City of Albuquerque Stormwater Construction Site Inspection Report

ESC File No.	D17E106	Project Name:	Legacy @ Journal Center		
NPDES Id. No.	NMR1007S	Location:	5001 Lang Ave. NE		
5/7/2021	Owner	Contractor			
Operator	Titan Development				
Contact name & title	Brian Patterson				
e-mail	bpatterson@Titan-Development.com				
Contact Phone #	505-998-0163				
COA Inspector	Thomas Evans		Start/End Time:	8:25 AM/8:30 AM	
Construction Phase:	infrastructure				
Type of Inspection:	Regular	Storm Event	Past Storm Event >0.25"	311/Complaint Follow Up	
Weather at time of inspection?	clear		Temperature: ~	68	
Estimated date of last storm 0.25" or greater	5/3/2021

**Legacy @ Journal Center**

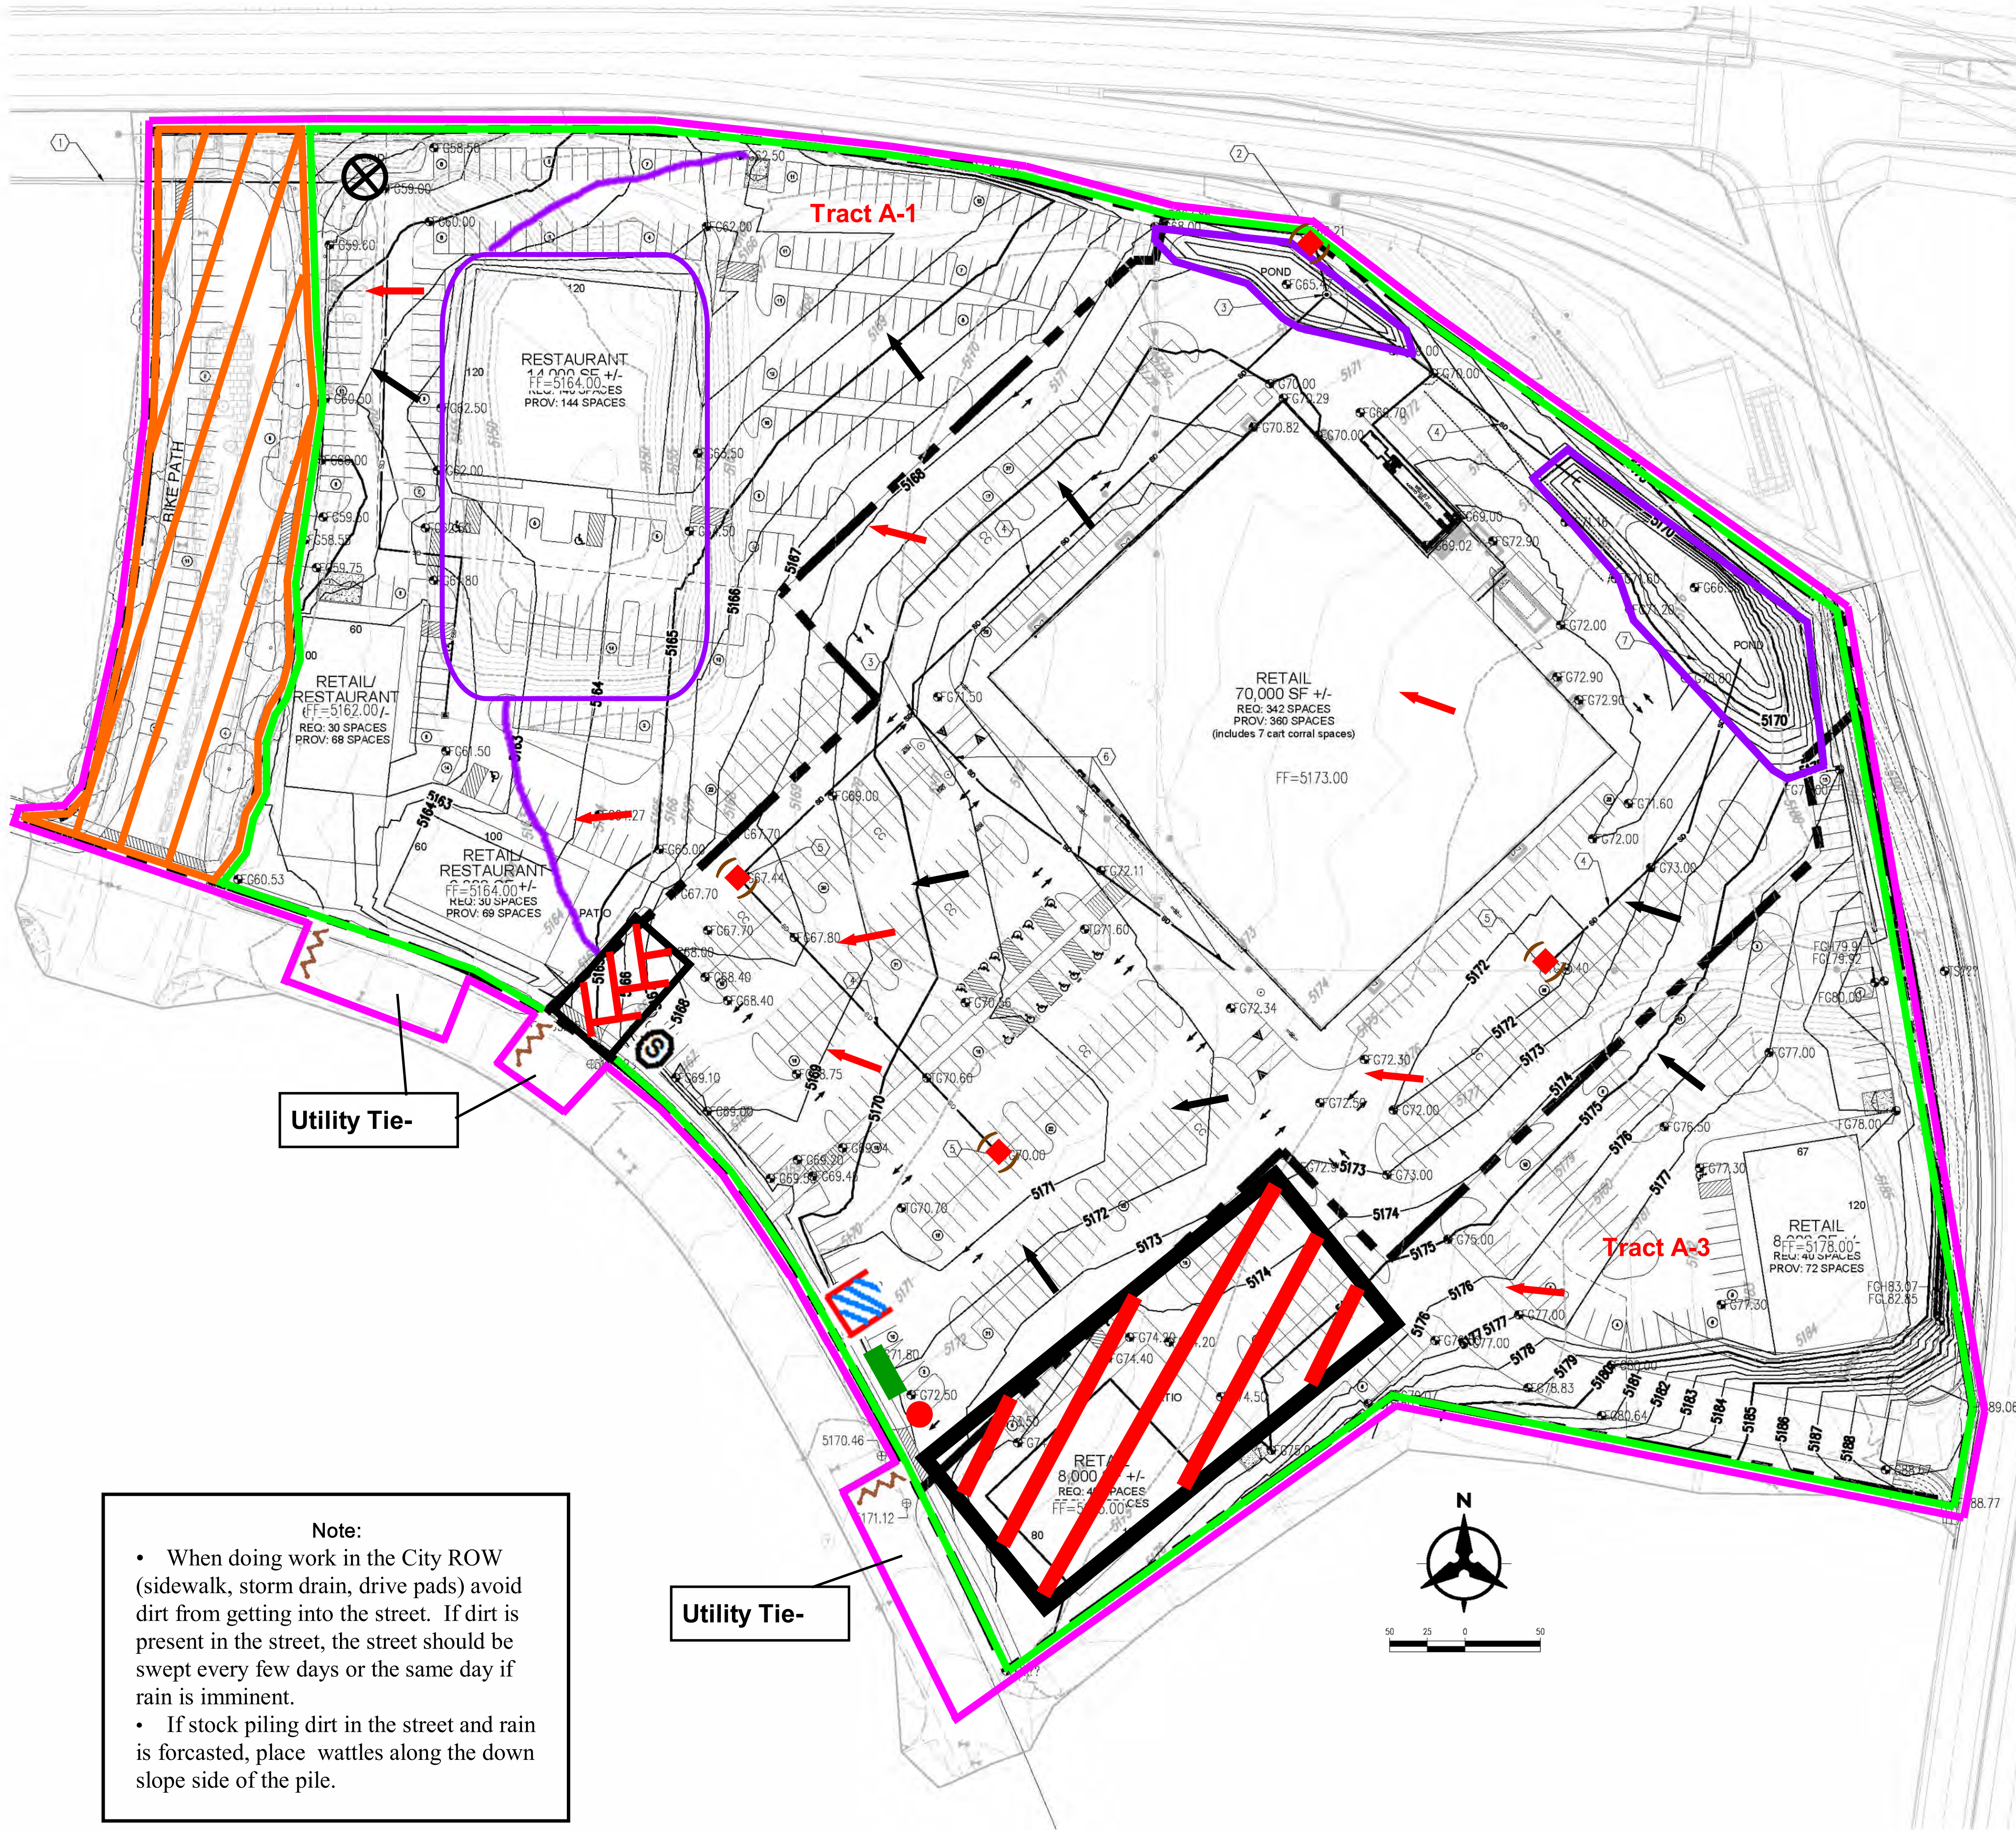
Item Number	Deficiency/ Corrective Action				
1	Section of silt fence on the East side is nearly gone. Replace this section of silt fence and continue maintenance.				
2	No posting of permit. Post signage of permit coverage in location that is visible to the public.				
3					
4					
5
